Re: Permit # SHL18-017
Project Name Lakeshores Group Community Dock
Project Address 5067 84th Ave SE (parcel # 407600-0080)
Reviewer Andrew Leon, Planner
Department Planning & Development

Below are our responses to your comments from December 15, 2022. Your original comments are in ***bold italics*** followed by our response in plain text.

SITE PLAN
(PROPOSED)
 SCALE 1" = 40'-0"

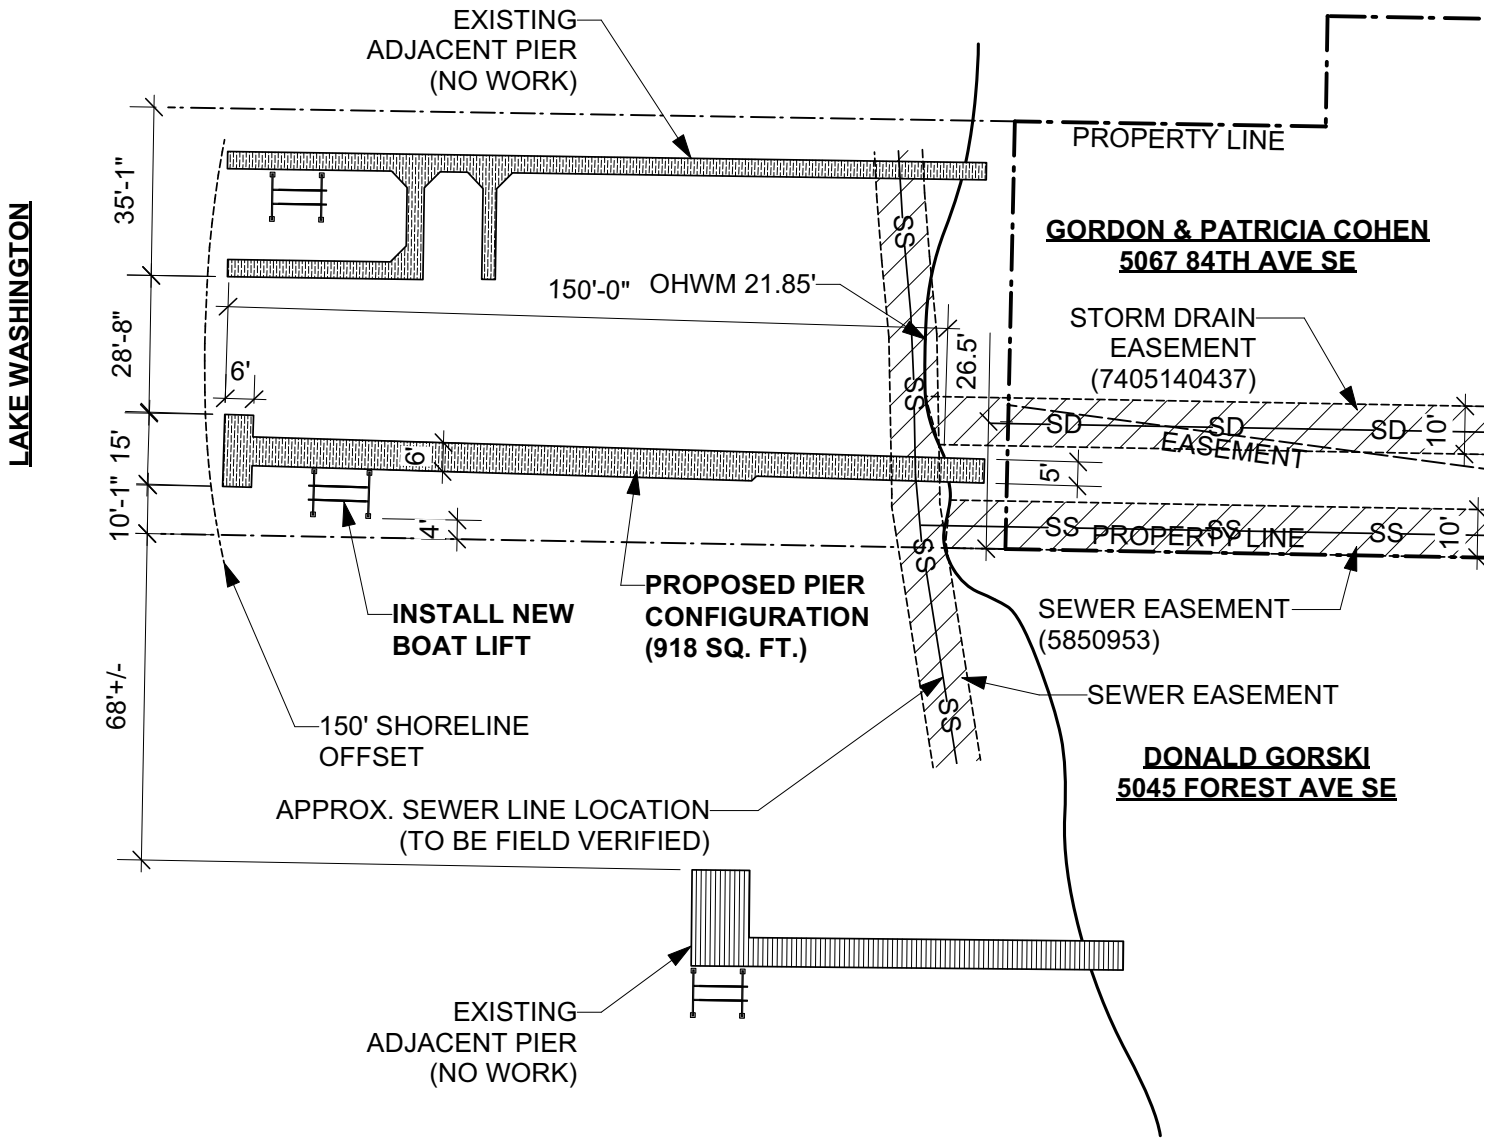
1. The proposed boat lift is located within the 10-foot lateral line setback from the lateral line to the south. Table D of MICC 19.07.110(E)(4) states that moorage facilities may only be located within the setback from a lateral line if the moorage facility is built pursuant to an agreement between adjoining property owners. Boat lifts are included in the definition for moorage facility.

In the last review letter, the City requested an agreement, in writing, between the owner of the subject property and the property to the south to install the boat lift in the proposed location. The applicant did not provide such an agreement in their submittal. The applicant shall provide an agreement, in writing, between the owner of the subject property and the property owner to the south to install the boat lift in the proposed location with their next submittal.

The boat lift is no longer being proposed and has been removed from the plans.
